**KIRKLEES METROPOLITAN COUNCIL
INVESTMENT & REGENERATION SERVICE**

Reference No:	2025/62/91379/E
Site Address:	19, Kertland Street, Savile Town, Dewsbury, WF12 9PU
Description:	Erection of first floor and roof extensions to form a second storey
Recommending Officer:	Jennifer Booth

DECISION - Refuse

OFFICER REPORT

23-006-31

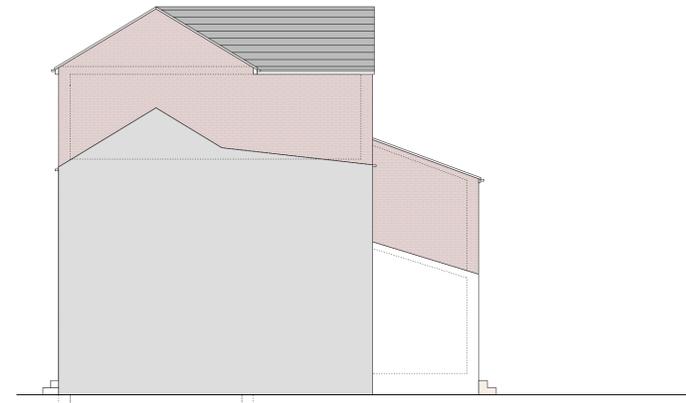
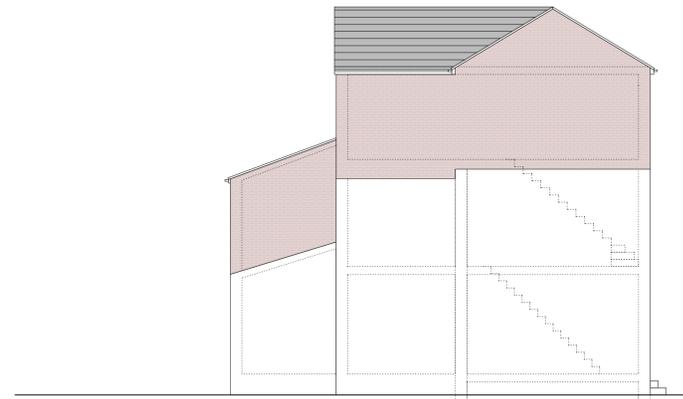
The eaves height of the dwelling would be increased from 6.1m to 9m, with the overall height of the dwelling increasing from 8.1m to 11m. The roof pitch would be retained over the original house and a perpendicular pitched roof over the existing two storey rear extension.

It is appreciated that the character of Savile Town is very urbanised, with older terraced properties which have been substantially extended to the rear and within the roof scape. However, the properties on Kertland Street maintain the height of the row at approximately 8m above the pavement level even with the existing roof alterations. The proposals would see the host property rise a further 3m above the row, which would form an incongruous feature.

Kirklees have adopted the House Extension and Alterations Supplementary Planning Document (SPD), which places emphasis through principles KDP1 and KDP2 on the character of the host property and the wider area. The supplementary document carries significant weight in the determination of planning applications. There is no current fall back such as potential under the General Permitted Development Order (GDPO) given the age of the property. Furthermore, the lack of any similar extensions to the properties within this row of properties on Kertland Street (which may have provided justification for such development contrary to current policy) is such that the raising of roof of the property would be out of character with the immediate uninterrupted terrace building group. As such, the upwards extension proposed given the scale and height, would not be acceptable in terms of visual amenity.

Having taken the above into account, the second floor extension would result in harm in terms of visual amenity for both the host dwelling and the wider street scene, thereby failing to comply with Policy LP24 of the Kirklees Local Plan (a) in terms of the form, scale and layout, KDP 1 & 2 of the House Extensions & Alterations SPD and the aims of chapter 12 of the National Planning Policy Framework.

1. The proposed raising of the roof, due to the design and height, would appear out of character with the host property and the neighbouring dwellings within this terrace row. Furthermore, the overall bulk and massing of the extension would not appear subservient to the original building and would therefore not promote good design. To permit the proposals would be detrimental in terms of visual amenity and contrary to policy LP24 of the Kirklees Local Plan, KDP1 & KDP2 of the House Extensions & Alterations SPD and advice within chapter 12 of the National Planning Policy Framework.
